65206819 – Shurgard House, Uxbridge Road, Hayes UB4 0HD

London Plan Fire Safety Report

10.08.2022

Revision: 02

DRAWING
SITE ACCESS PLAN
AS PROPOSED

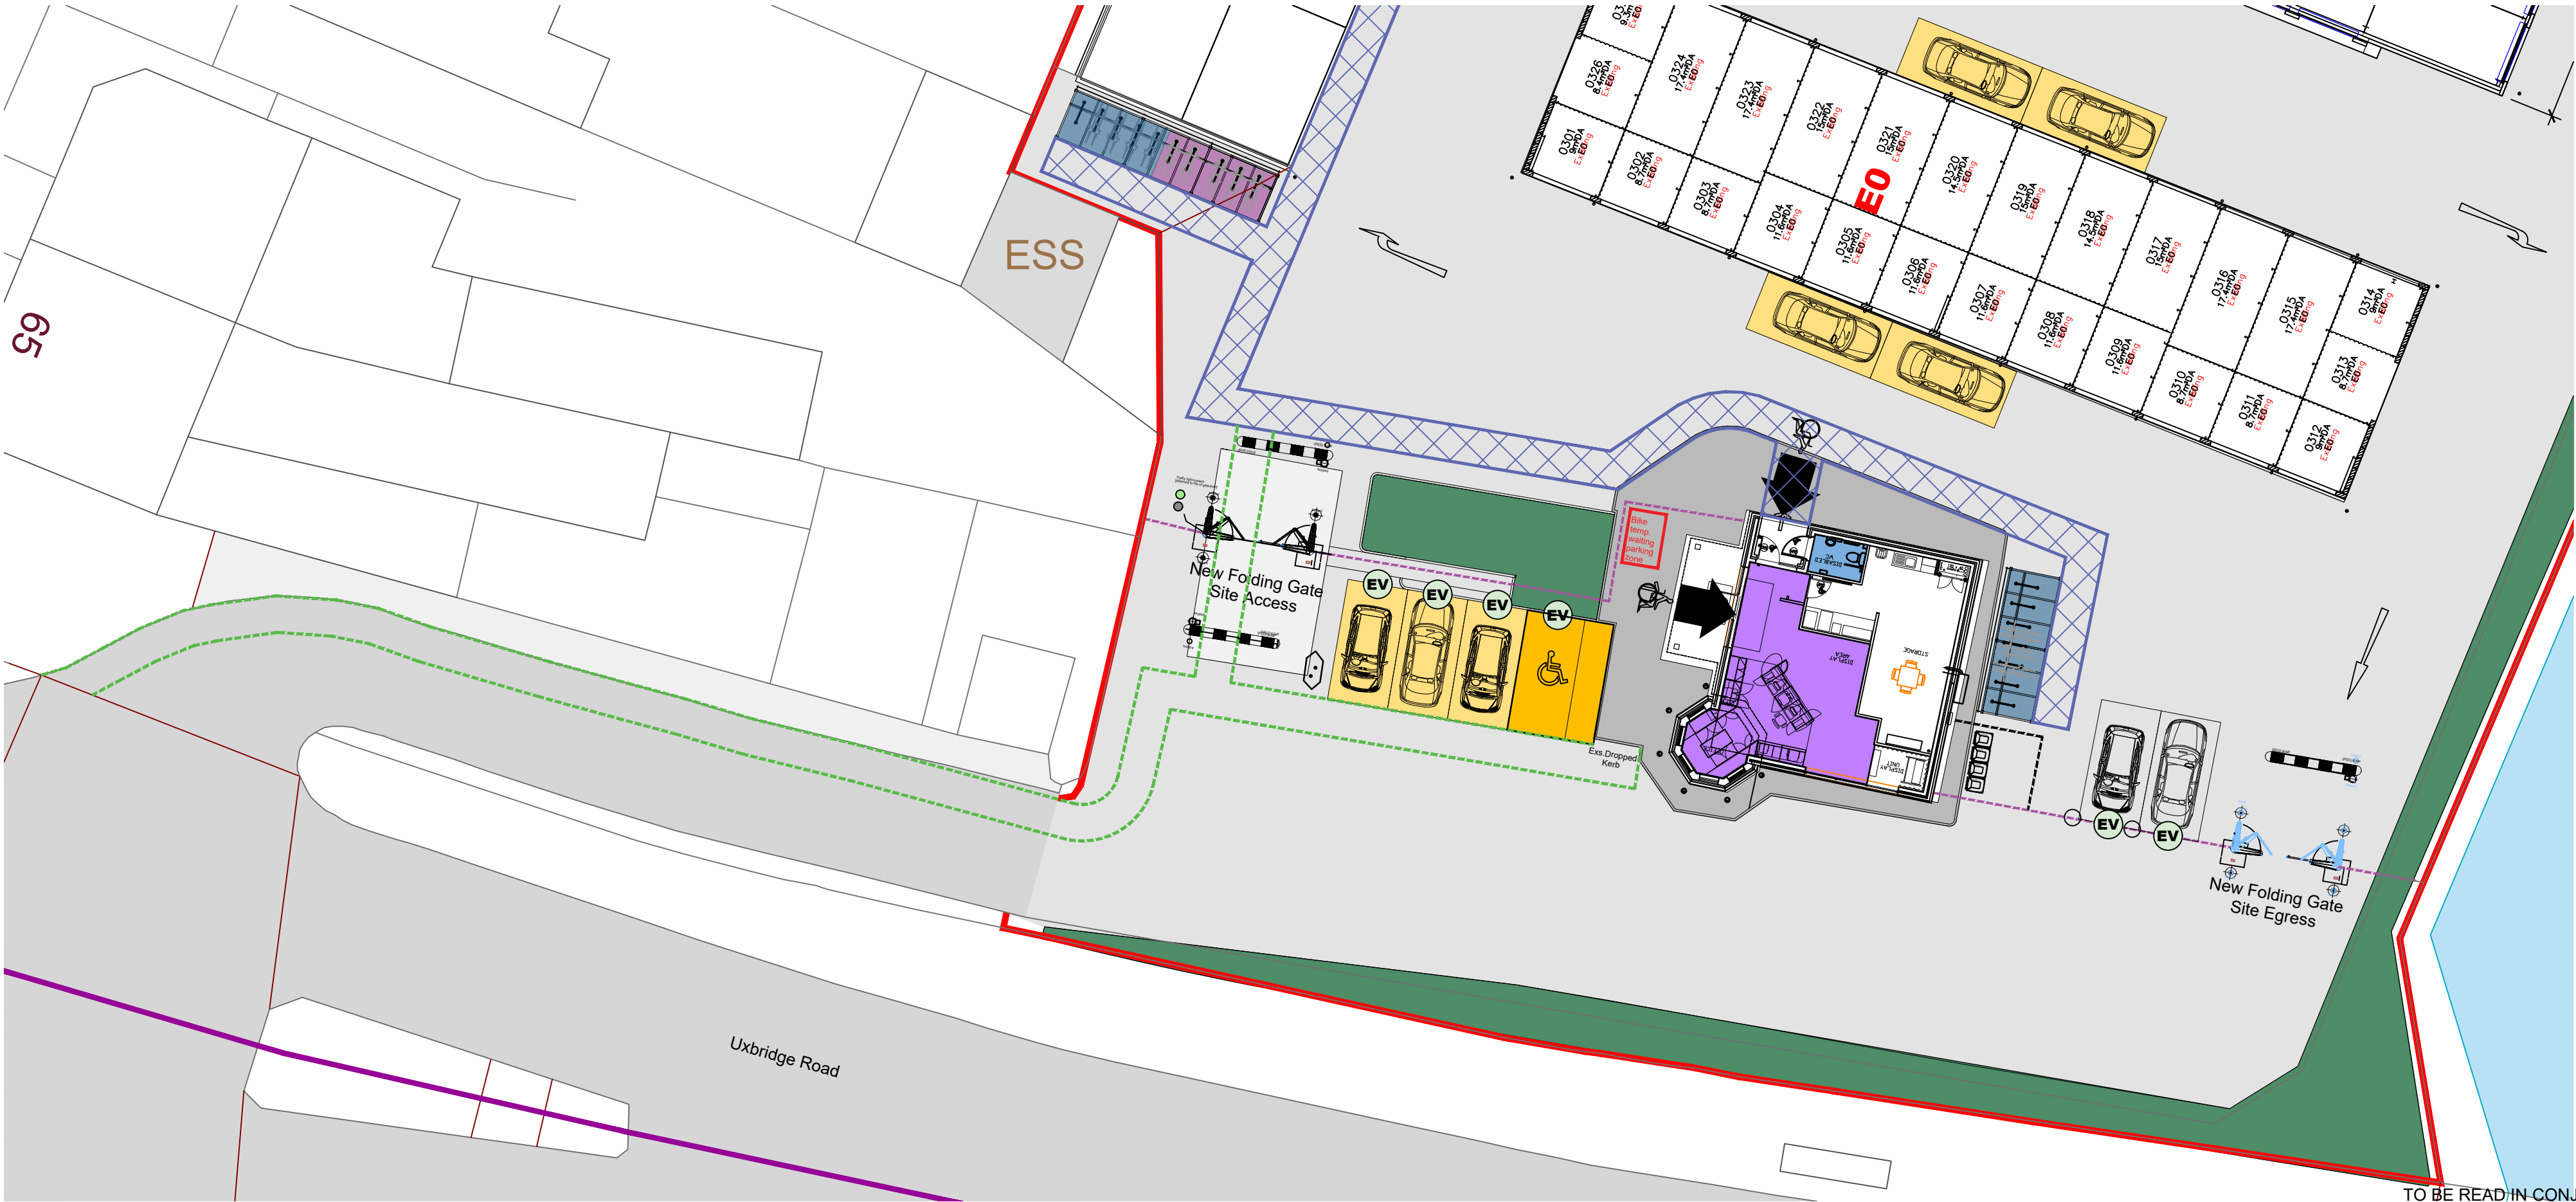
- Total building floor area is now 9824m<sup>2</sup> so 50% of access to the perimeter is required. Due to dead ends and maximum 20m reverse limitations the through road and gate to the top right of the site needs to provide a route through for an appliance plus a door along this elevation.

- The proposed building perimeter measures 223m, 50% of this is 111m. Due to dead ends and maximum 20m reverse limitations the site needs to provide a through route for a fire appliance in order to meet 50% perimeter access. If the through road and gate to Tollgate Drive to the top right of the building could be utilised in the event of a fire, then the fire brigade could access up to 130m or 52% of the perimeter of the building.

- Every elevation to which vehicle access is provided should have a door, a minimum of 750mm wide, to give access into the building. The maximum distance between doors, or between a door and the end of the elevation, is 60m (e.g. a 150m elevation would need a minimum of two doors). The western elevation will require an additional door 60m from the door proposed in the new extension.

- The unit is surrounded by access roads/hard standing, if the gate to Tollgate road can be used the site is considered to be suitable to meet the requirements for fire service access.
- We assume hydrant locations are acceptable due to the building's urban location.
